29th May, 2012

Mining & Industry Projects
Department of Planning
GPO Box 39
SYDNEY NSW 2001

RE Orange Waste Project Application 09_0025 MOD 1

PROJECT NUMBER: 208212	DRAWING NUMBER: 24_ EV13	REV: E
SOURCE: SIX VEI/ER

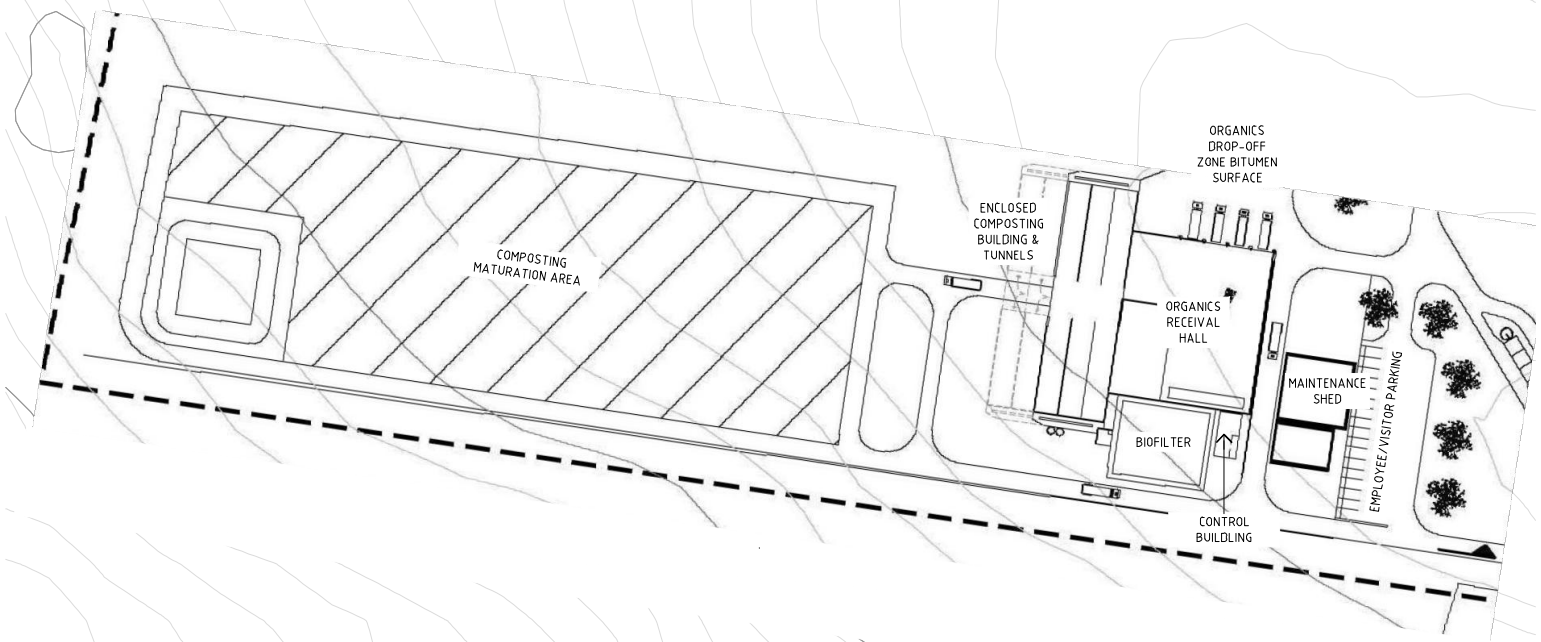
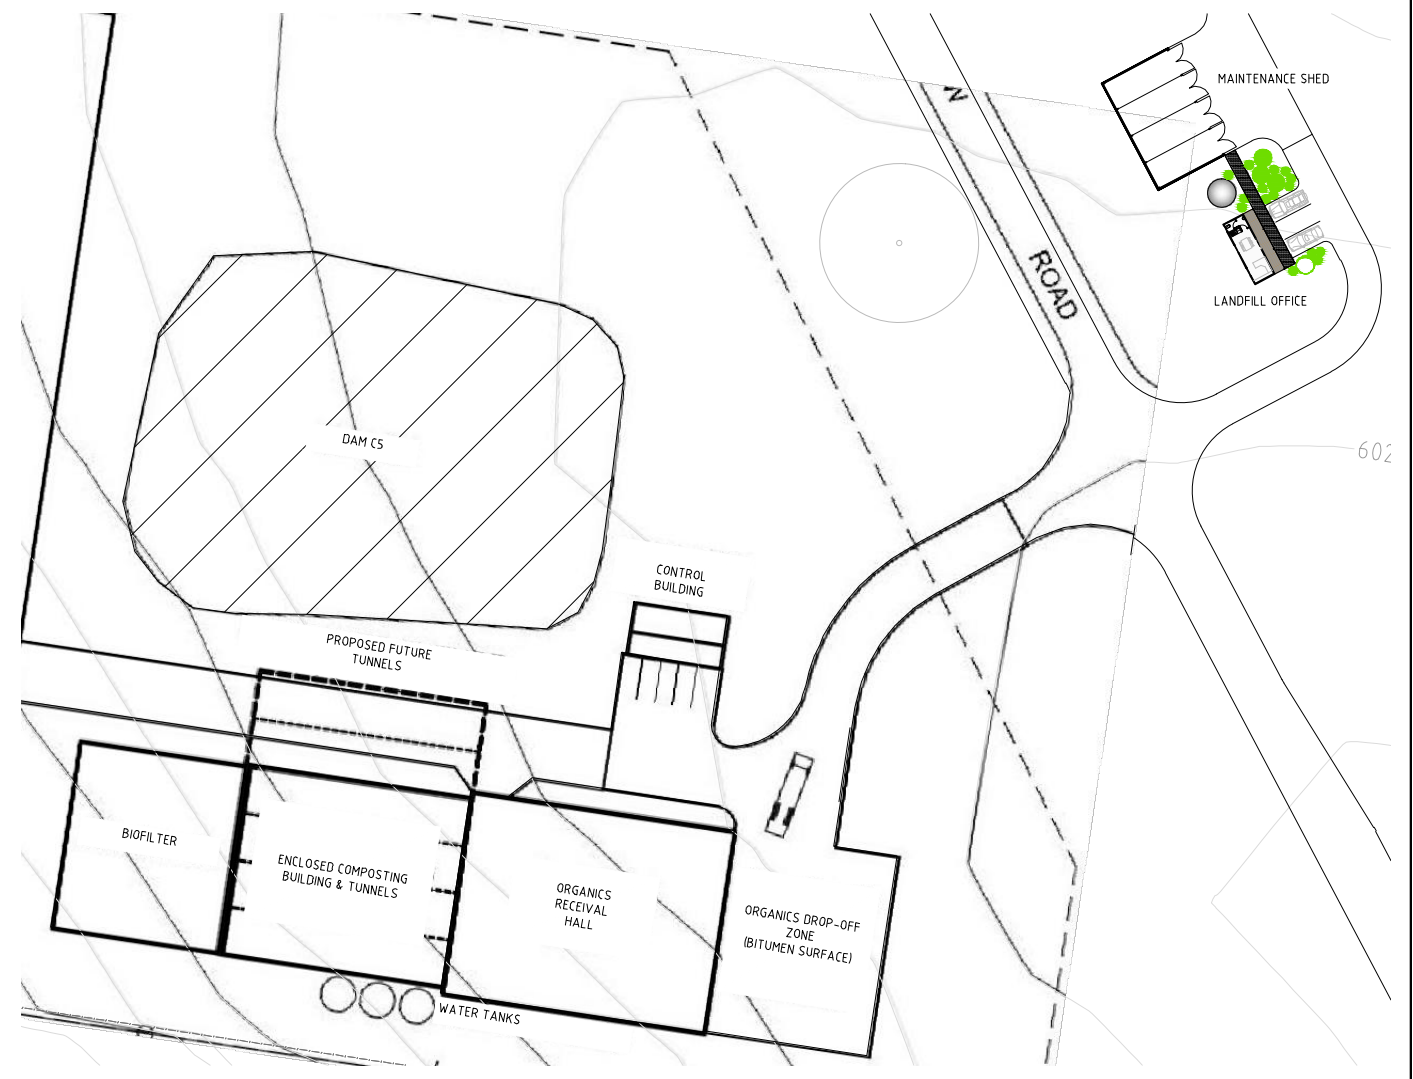
Conversely, the drawings provided for the Euchareena Road site (Drawings EV13-EV16) provide scant detail on all aspects of the proposed building layout. This is unacceptable given the potential impacts of the proposed modification to the composting building are almost indiscernible due to the diminutive scale of the drawings provided. The drawings do not show the open side of the building and where that side will be sited and this aspect in particular is critical to the objective assessment of any impacts. Similarly, no detail has been provided on the design of the enclosed composting tunnels, i.e. are they fully enclosed to prevent the escape of noise and odour?

For the purpose of our submission it is assumed that the open side of the composting building is that adjacent to the “organics drop-off zone” (as illustrated in the previously approved diagram), on the eastern side of the building.

By realigning the composting building the previous noise and odour assessments are altered. Having the open side of the building facing east has ramifications for the nearest residence, “The Shades” as;

- “The Shades” is 800m from the building in an easterly direction
- The open side of the building is in a direct line from the composting facility “The Shades”
- Prevailing winds for the majority of the year are in a general westerly direction,(towards “The Shades”)
- Any buffering effect from the wall at the eastern side of the building as previously approved has been removed.
- The previous noise assessment was based on the composting building being enclosed.
- The 2009 Odour Assessment was based on the approved building alignment, not that currently proposed.

- The EA stated the storage of the collection dam (Dam C) would be “*about 0.5ML*”. The current proposal increases that storage to 10ML.
- The statement that “*Dam C has now been split to form 5 smaller dams*” is misleading as evidenced in drawing EV14.

- The quality and purpose of water stored in the new dams C1-C5 is unclear. Whilst it is stated that the function of these dams “*remains unchanged*”, the original purpose of Dam C was as capture and storage of leachate from the compost maturation pad. Does this mean that significantly more leachate is to be generated from the composting facility or are these dams to capture stormwater runoff, or both?

We refer to the proponents Statement of Commitments where assurance is given that "*Selective landscaping would be positioned around the office, weighbridge and enclosed composting plant*". Our submission of March 2012 requested clarification on the apparent removal of the landscaping around the composting building, (not screening and bunding as in the proponent's response). We reiterate our concerns as their absence is again apparent in drawing EV14. This is of particular concern as;

2 PROPOSED SOUTHERN ELEVATION

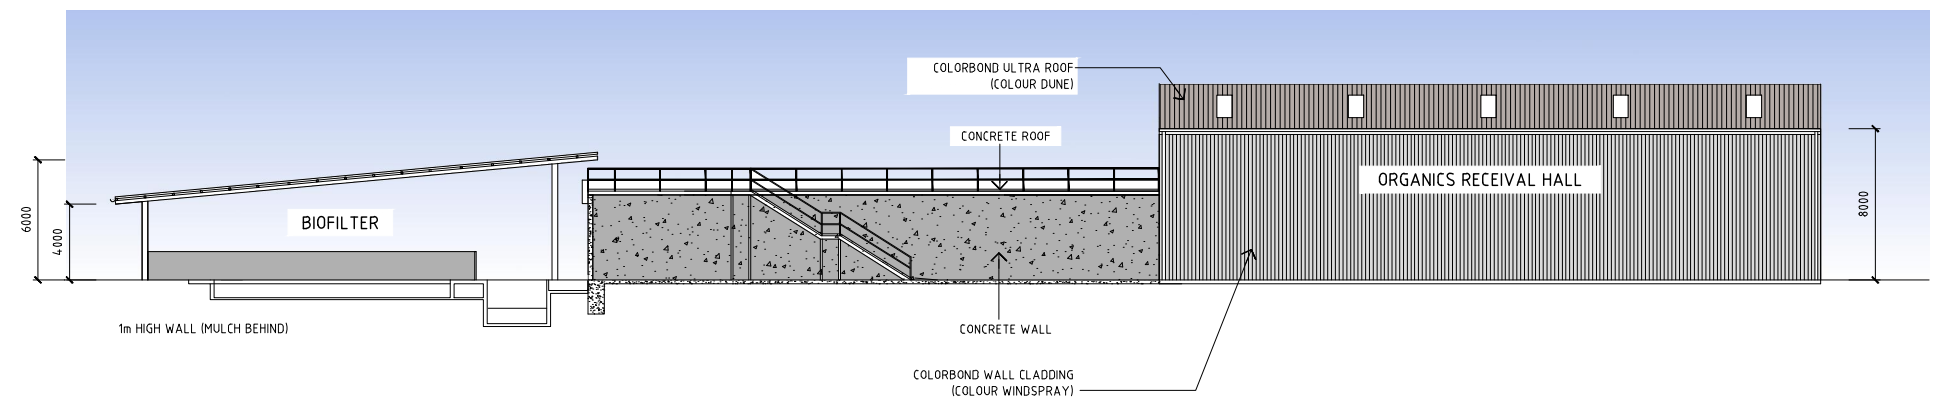
- The proponents' decision to separate the composting functions from Council operations and potentially avoiding their commitment to landscape areas surrounding buildings on site to improve visual amenity.
- The change in colour of the building from light green hues to concrete and greys which obviously increases the visual impact of the composting building.
- Landscaping on the eastern side of the composting building would provide screening from nearby residences.
